FC/16/17

From: Lee Martin [REDACTED]
Sent: 12 January 2012 15:00
To: Eve Hearsey
Cc: Philip Satchell
Subject: ASDA Worthing - Additional Proposed Alterations
Attachments: West Boundary Mods.pdf

From: Eve Hearsey [REDACTED]
Sent: 07 December 2011 12:16
To: Christine Tetlow
Cc: Karl Roberts; Nikolas Antoniou
Subject: RE: ASDA Worthing - Additional Proposed Alterations

Proposed Elevations

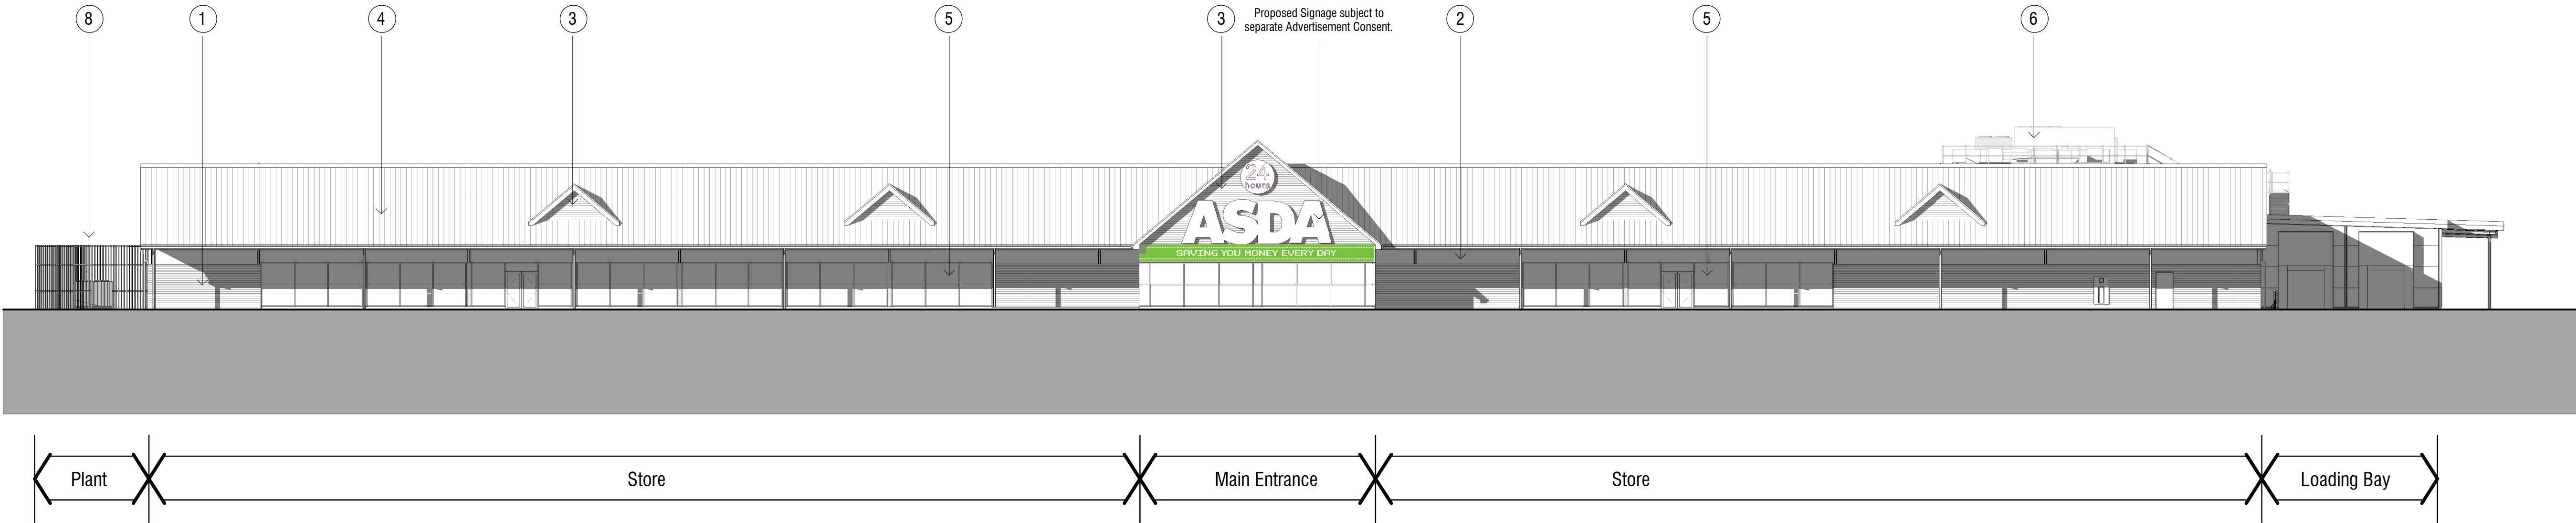
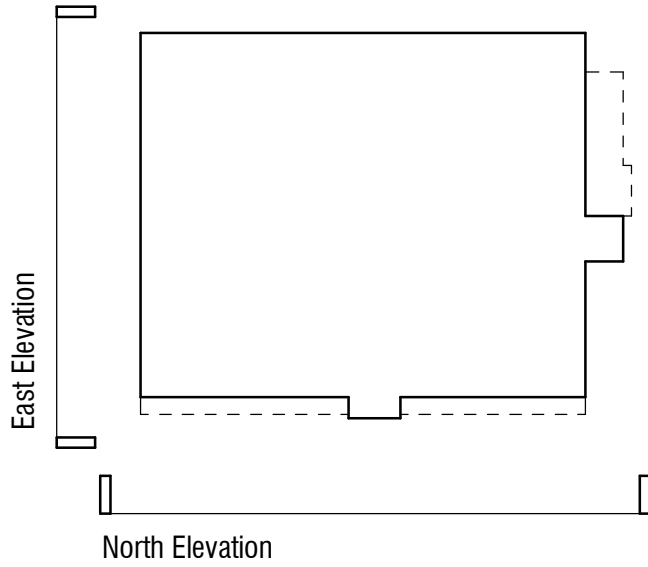
Drawing No. 10.120.A(00)30_03 Revision A Proposed North & East Elevations
Amendments

- A) removal of 2 no. dormers along mansard roof with remaining 5 dormers repositioned - NMA;
- B) increased area of curtain walling - NMA & DOC;
- C) areas for signage - Advertisement Consent;
- D) reduced columns along front edge of mansard roof - NMA;
- E) access doors relocated to suit internal layout - NMA;
- F) window fenestration remove - NMA and

Proposed Roof Plan

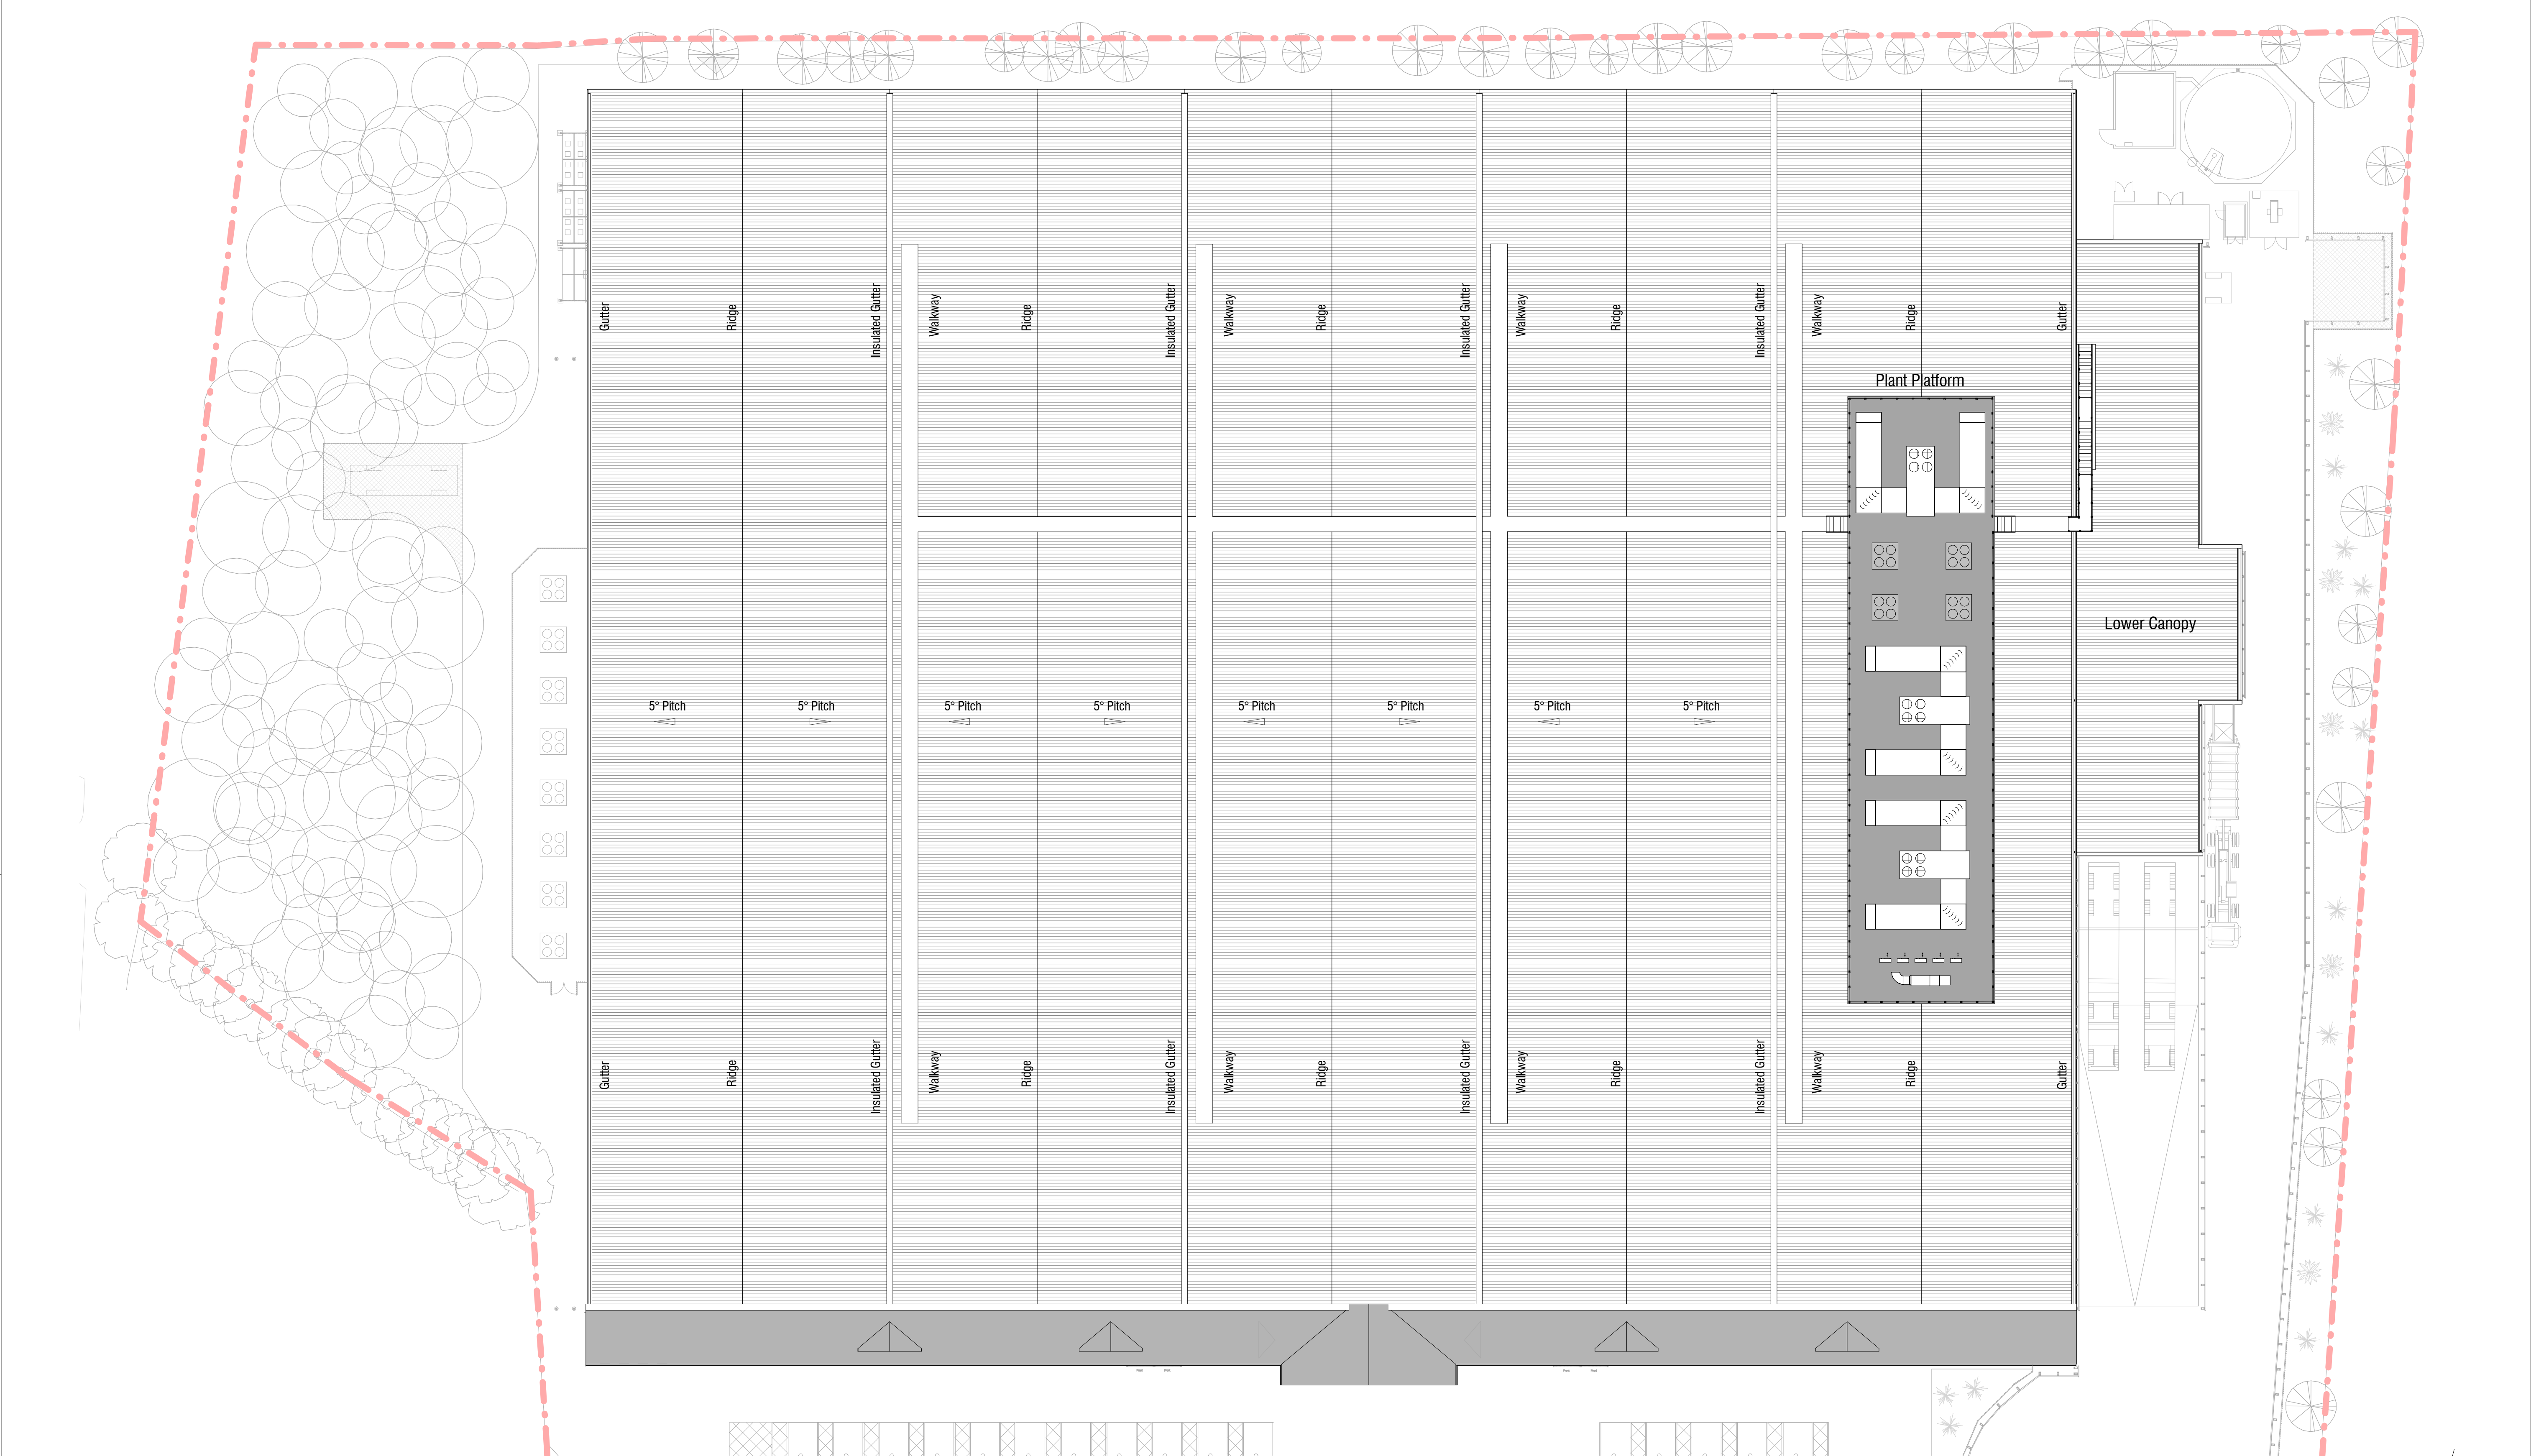
Drawing No. 10.120.A(00)01_01 Revision A Proposed Roof Plan

Proposed Site Plan

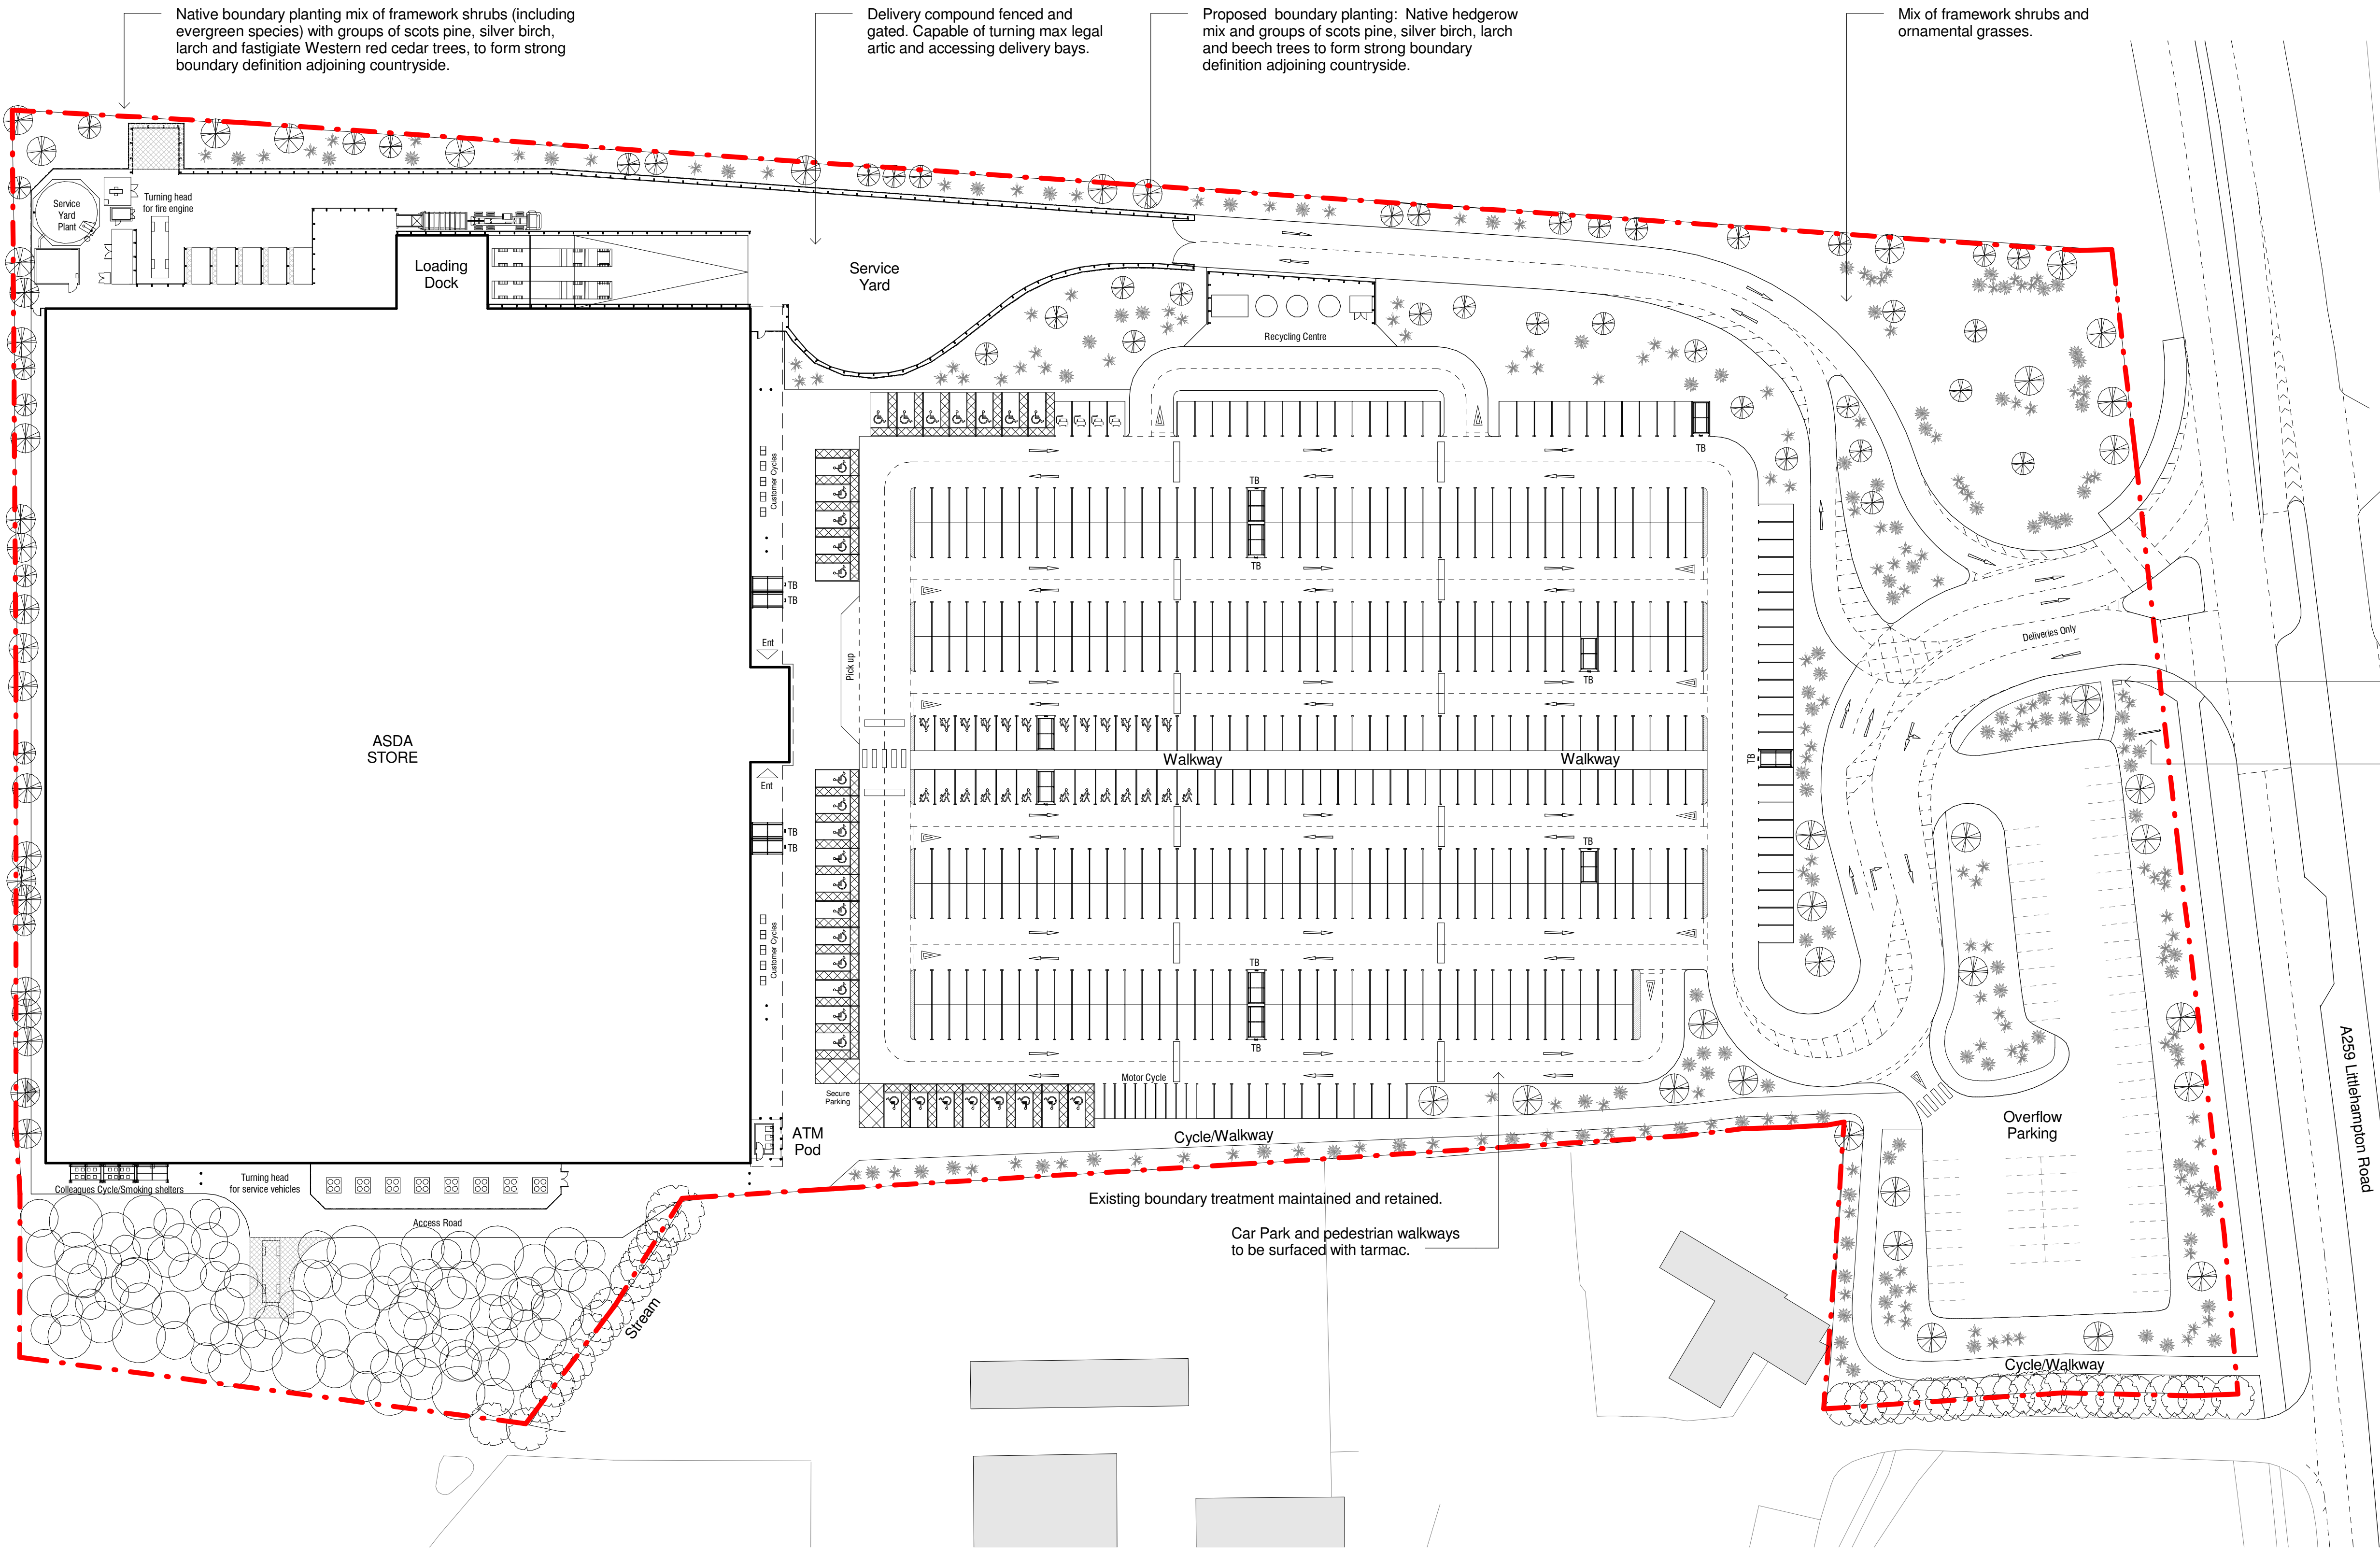
In readiness of the meeting and further to the e-mail that you sent to Christine Tetlow, of Asda Stores, we would like to clarify/ confirm some of the issues that have been raised with regard to the proposed site plan.

The first issue that has been raised is the loss of the landscape buffers within the main body of the parking area. From past experience Asda have found that landscaping in the car park is never a great success and works better in more robust perimeter landscape buffers. Hence we have removed the landscape buffers in the car park and have look to add more quality and definition to the extended landscape areas to the north of the site separating the highway and main body of car park.

With regard to the second comment about the turning head, on the south east of the site, we can confirm that the turning head is required for the Statutory water authority to service the existing water main/ hydrant that is located on this side of the building.

The alterations to the landscaping along the west boundary is a result of the need to provide a suitable turning head for a fire appliance. To comply with current regulations a fire appliance needs to have direct access to 50% of the store and we can provide this to the north and west elevations. Whilst the fire appliance can drive forward into the yard and access this elevation, the regulation states that the fire appliance must not have to reverse more than 20m, hence the need for the turning head. We have attached a simple sketch plan which shows a possible alternative layout to help maintain as much of the landscaping as possible.
